# Construction Drawings\_V2\_Comments.pdf Markup Summary

CE1.6

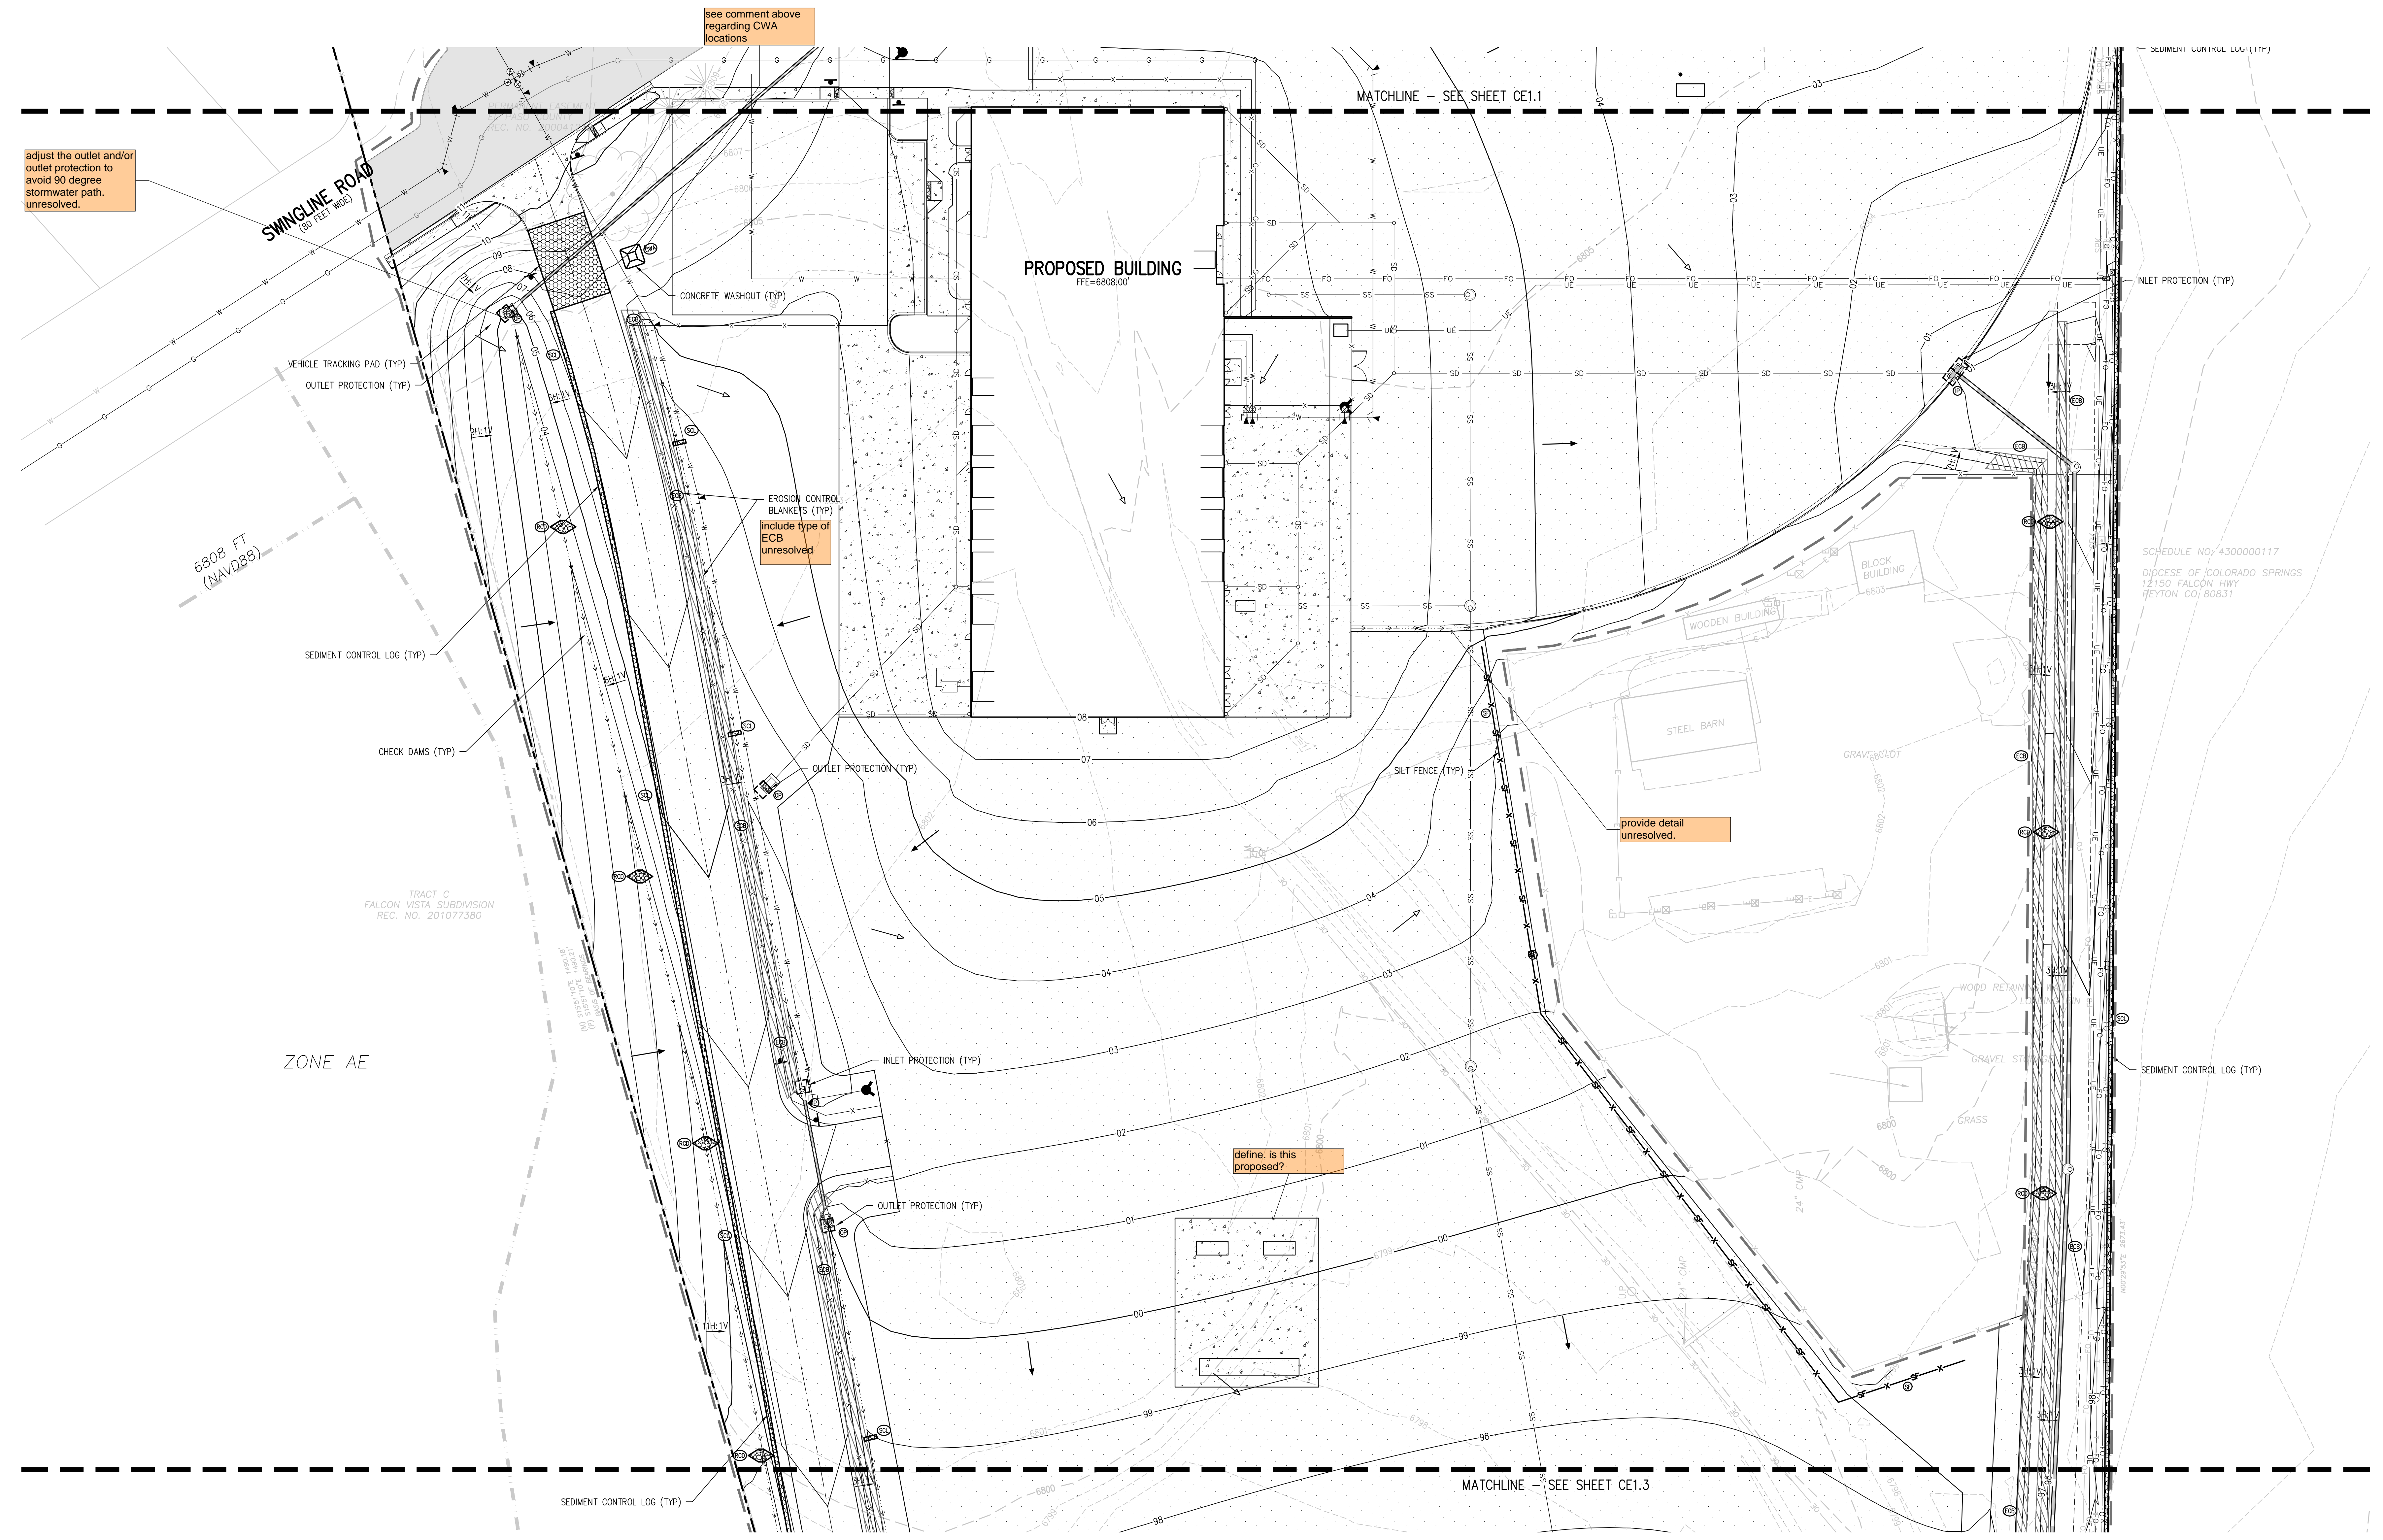
adjust the outlet and/or outlet protection to avoid 90 degree stormwater path. unresolved.

provide detail  
 unresolved.

include type of ECB  
 unresolved

SF doesnt seem necessary. please explain reasoning.

define. is this proposed?

CE1.7

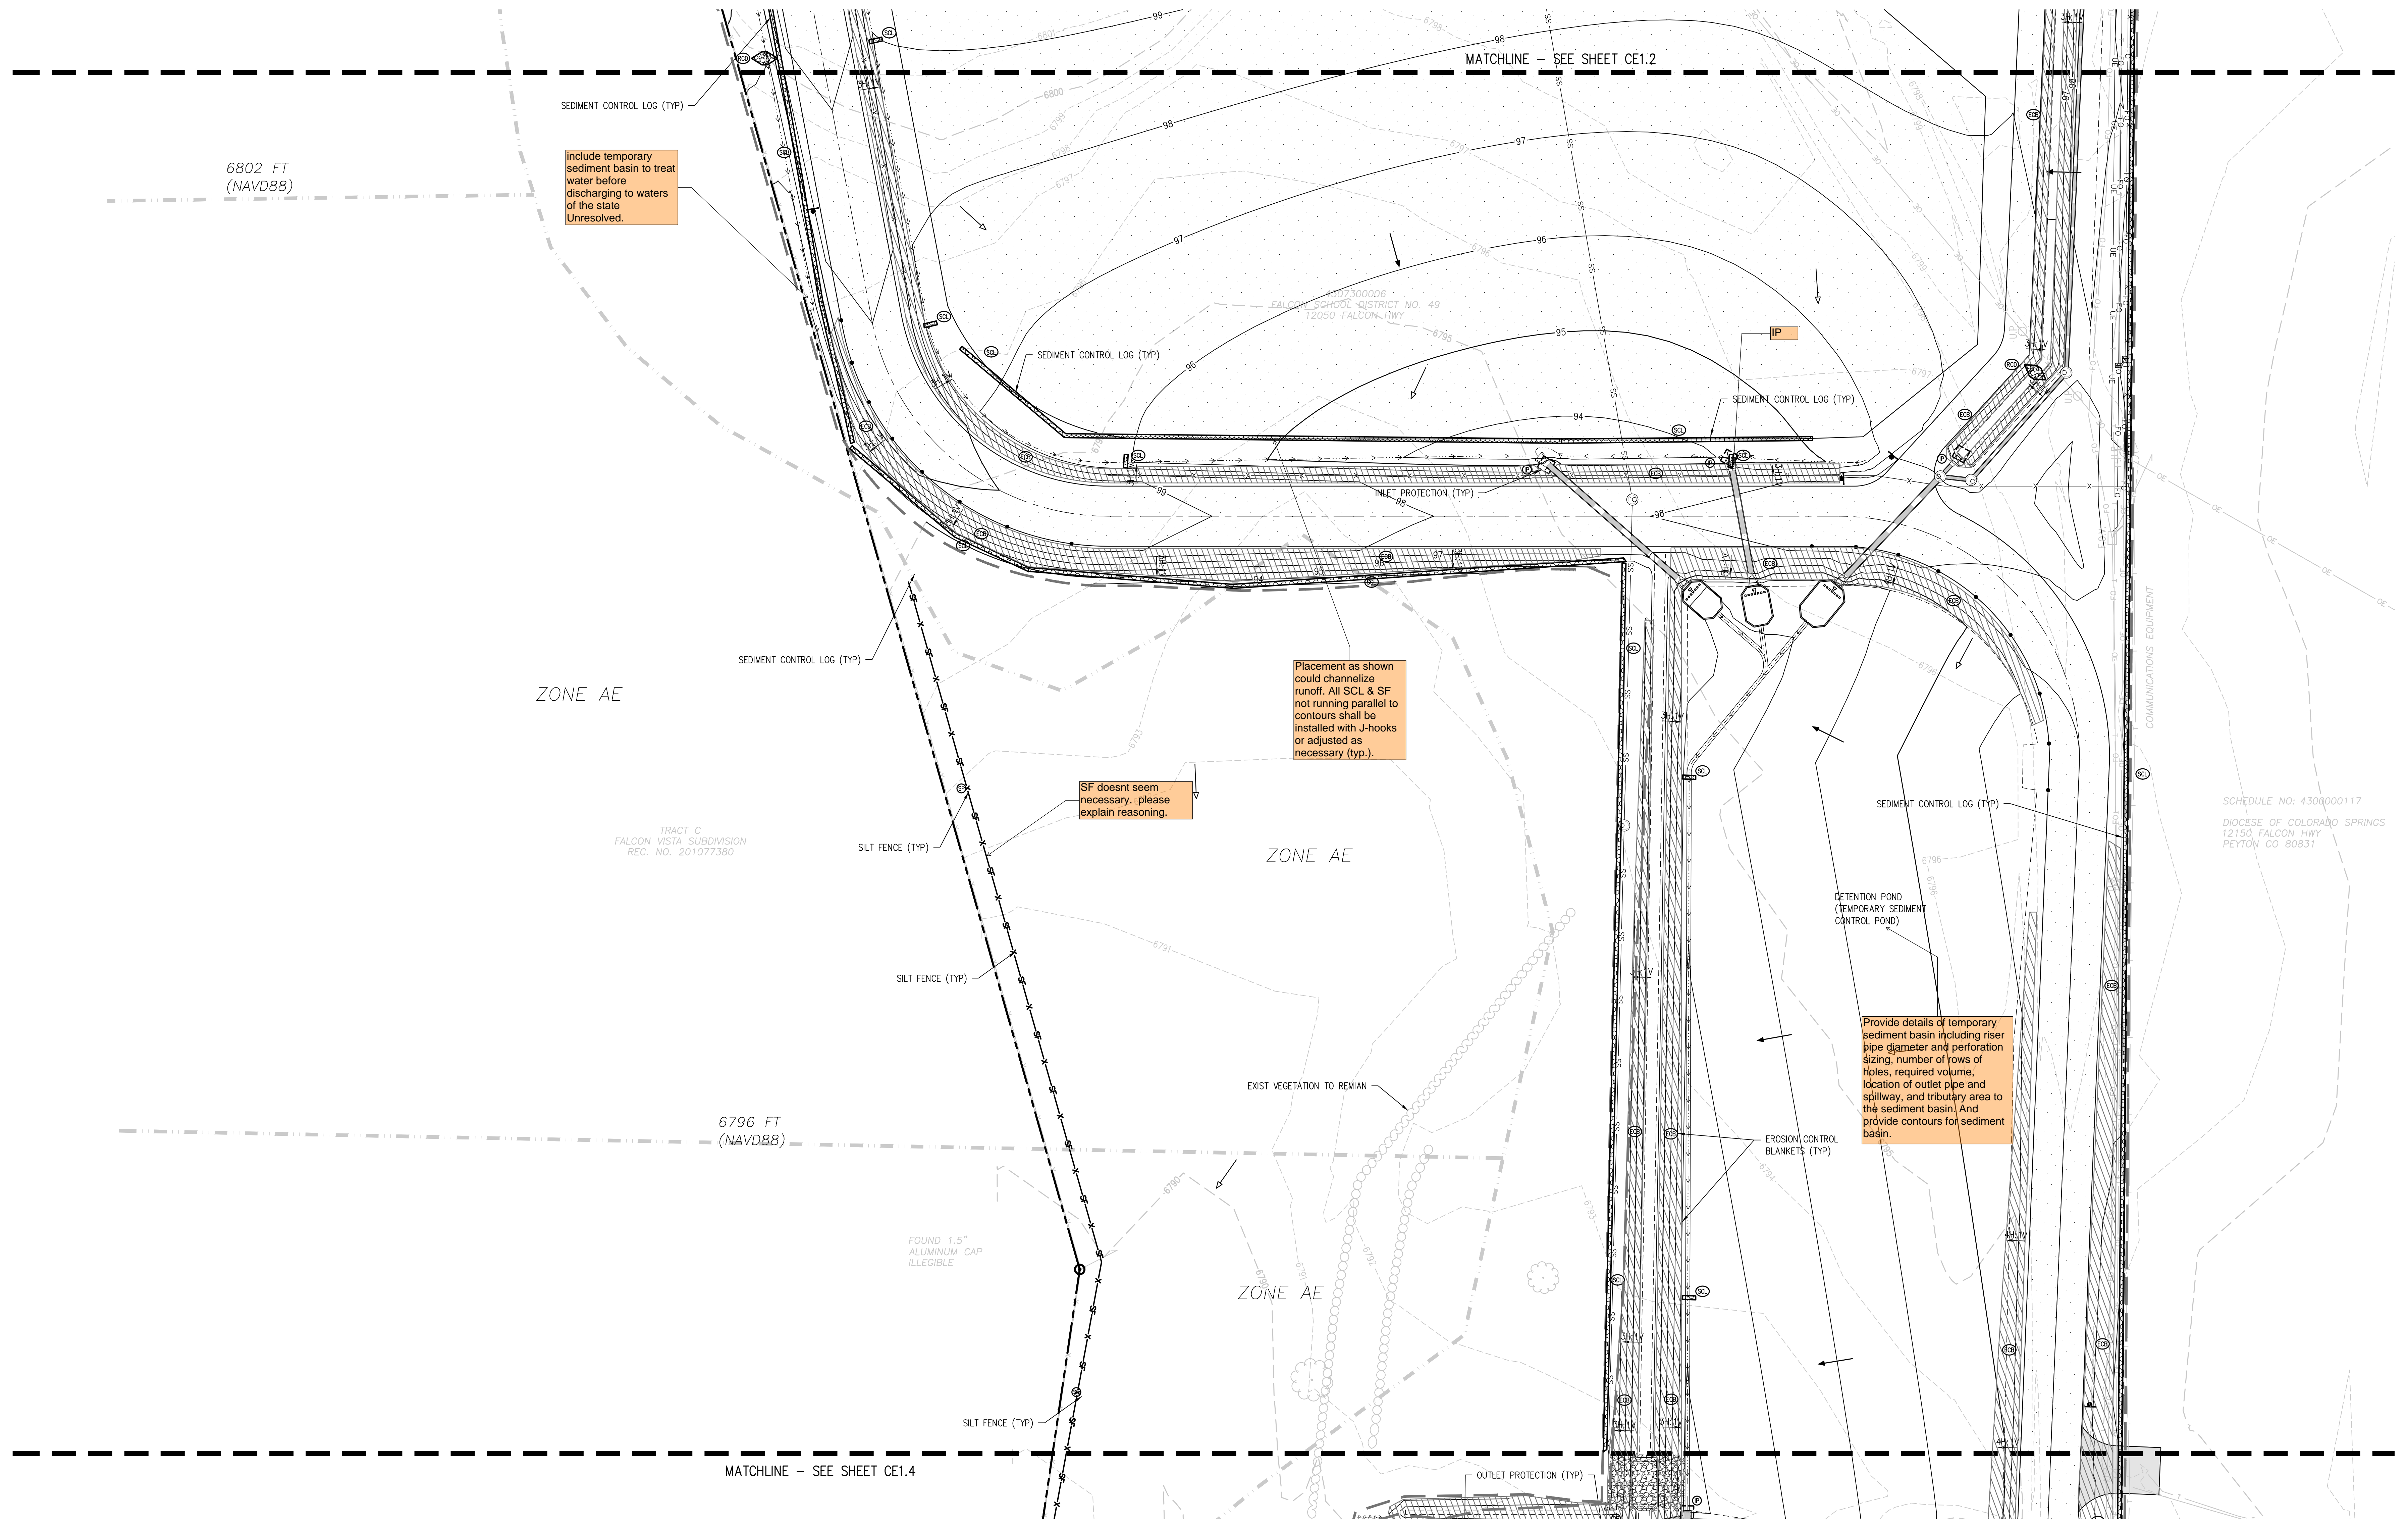
Placement as shown could channelize runoff. All SCL & SF not running parallel to contours shall be installed with J-hooks or adjusted as necessary (typ.).

Provide details of temporary sediment basin including riser pipe diameter and perforation sizing, number of rows of holes, required volume, location of outlet pipe and spillway, and tributary area to the sediment basin. And provide contours for sediment basin.

include temporary sediment basin to treat water before discharging to waters of the state  
 Unresolved.

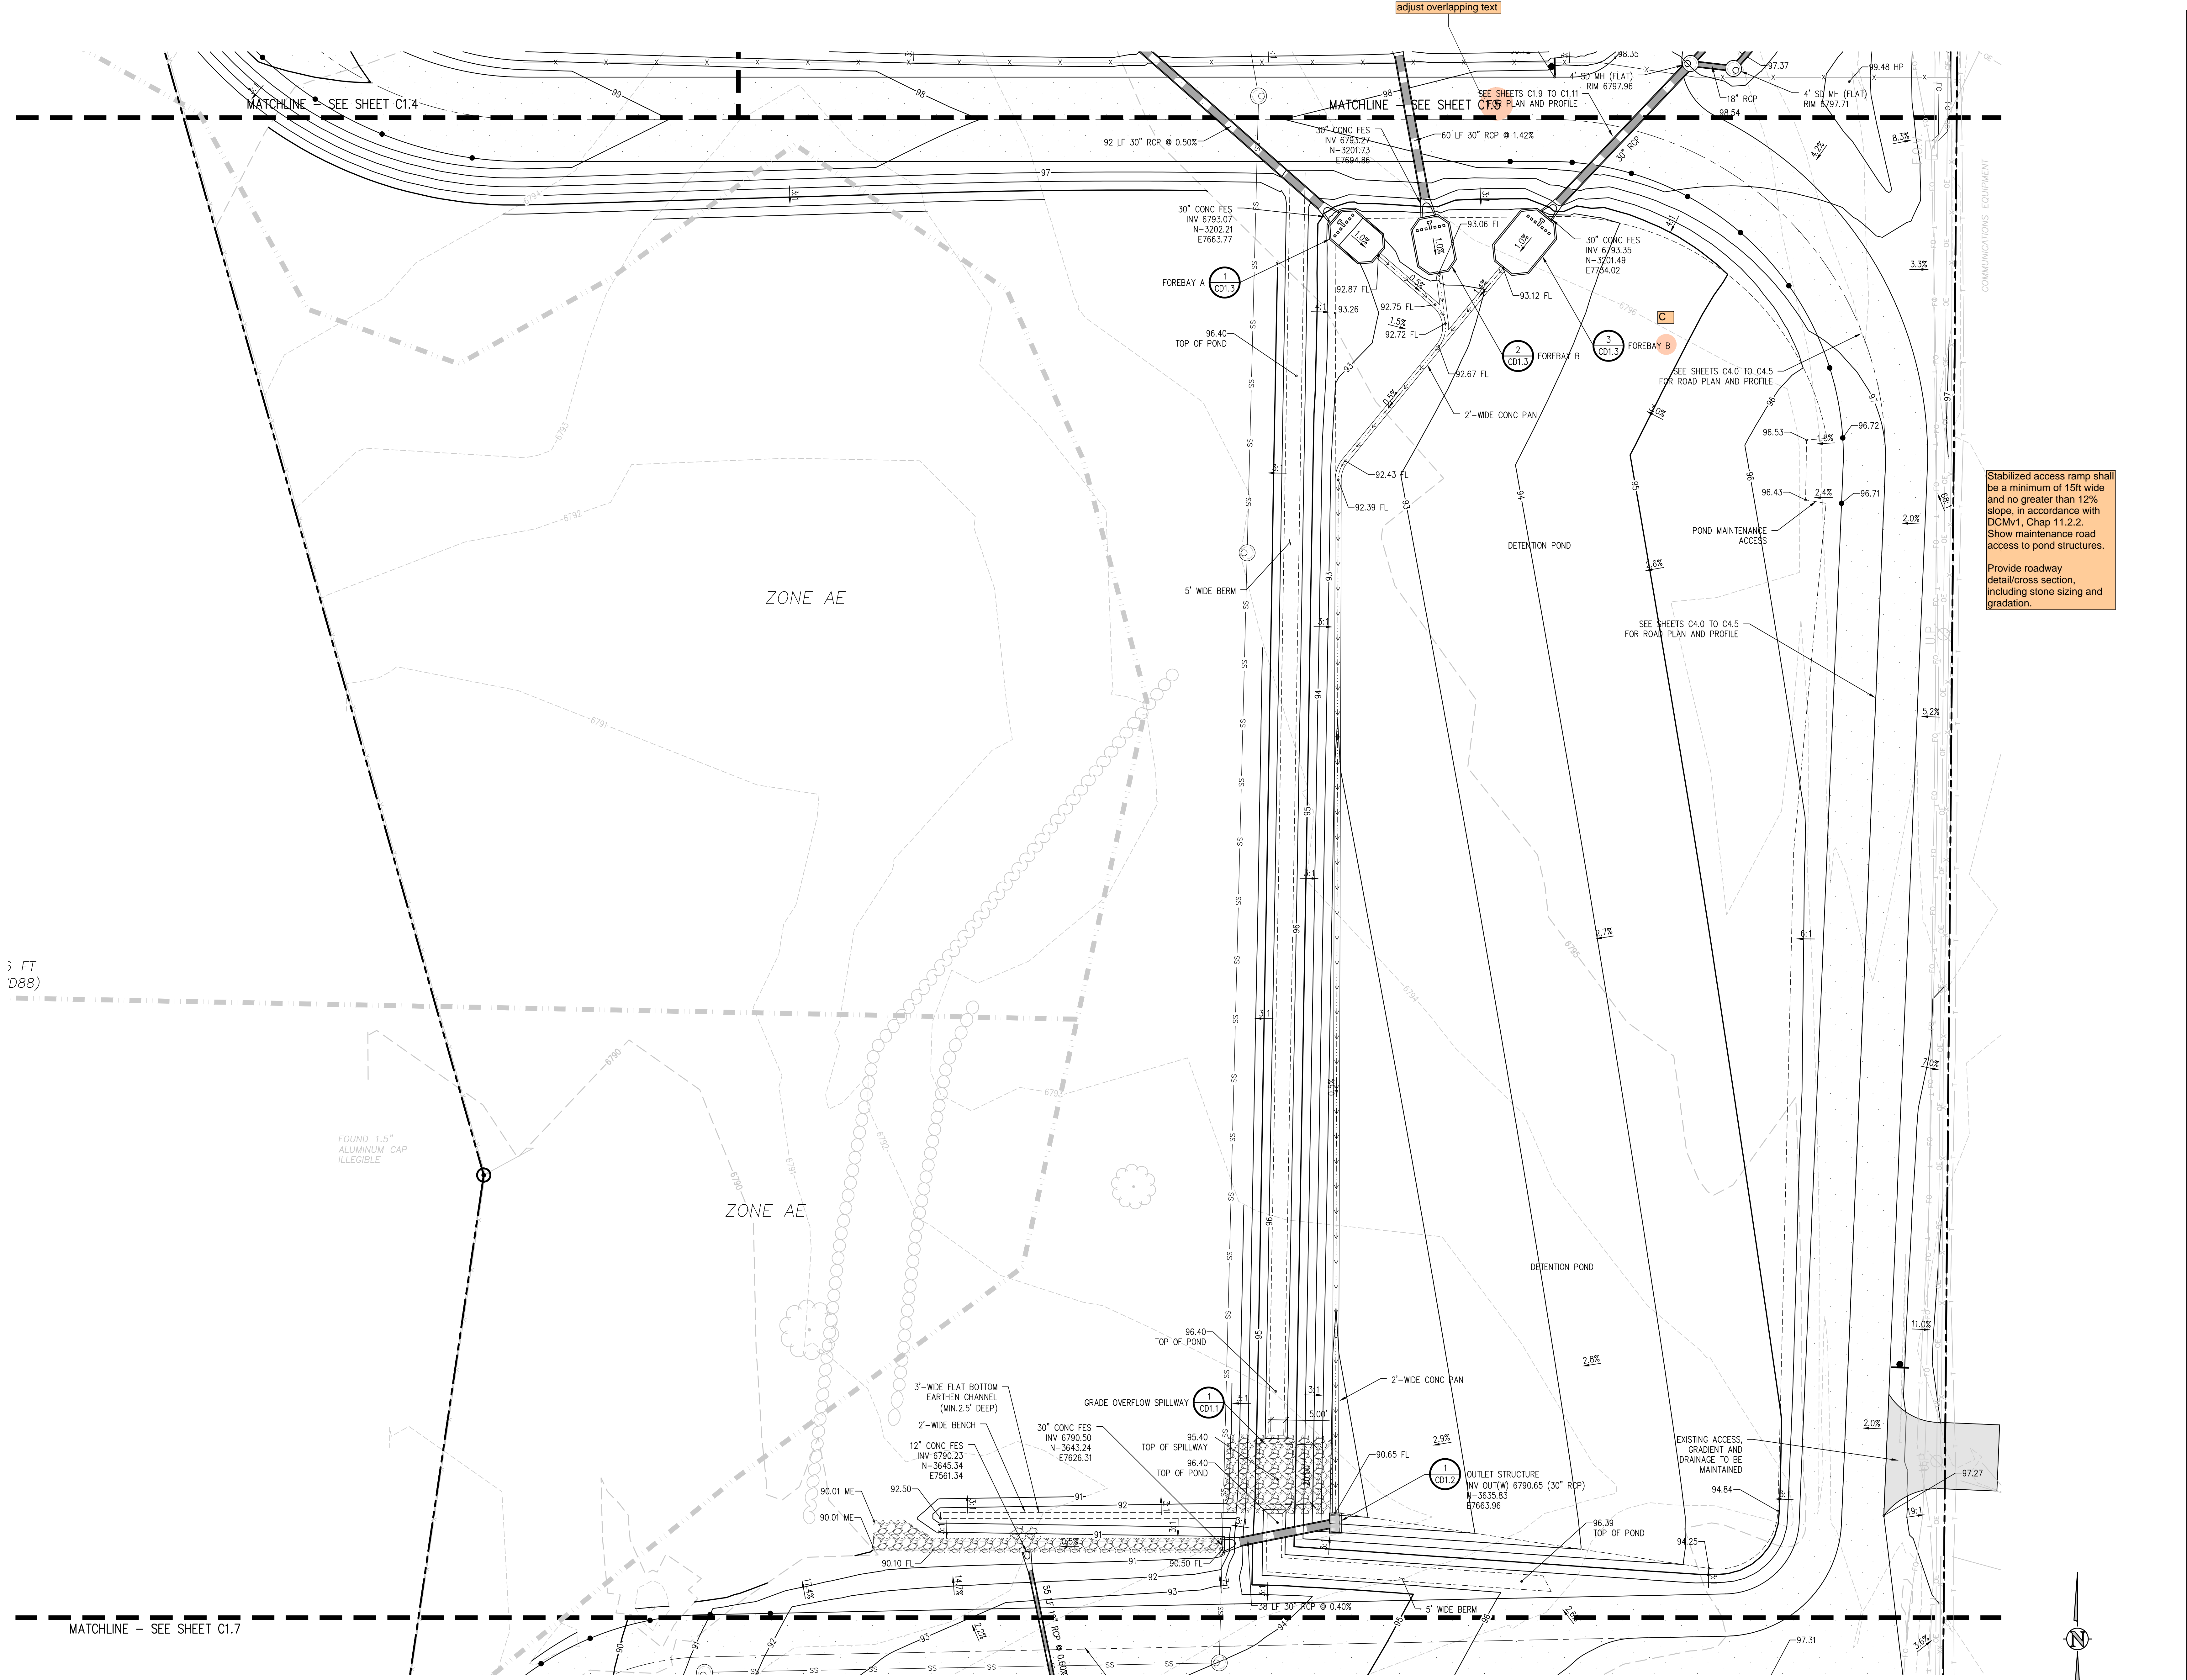
Stabilized access ramp shall be a minimum of 15ft wide and no greater than 12% slope, in accordance with DCMv1, Chap 11.2.2. Show maintenance road access to pond structures.

Provide roadway detail/cross section, including stone sizing and gradation.
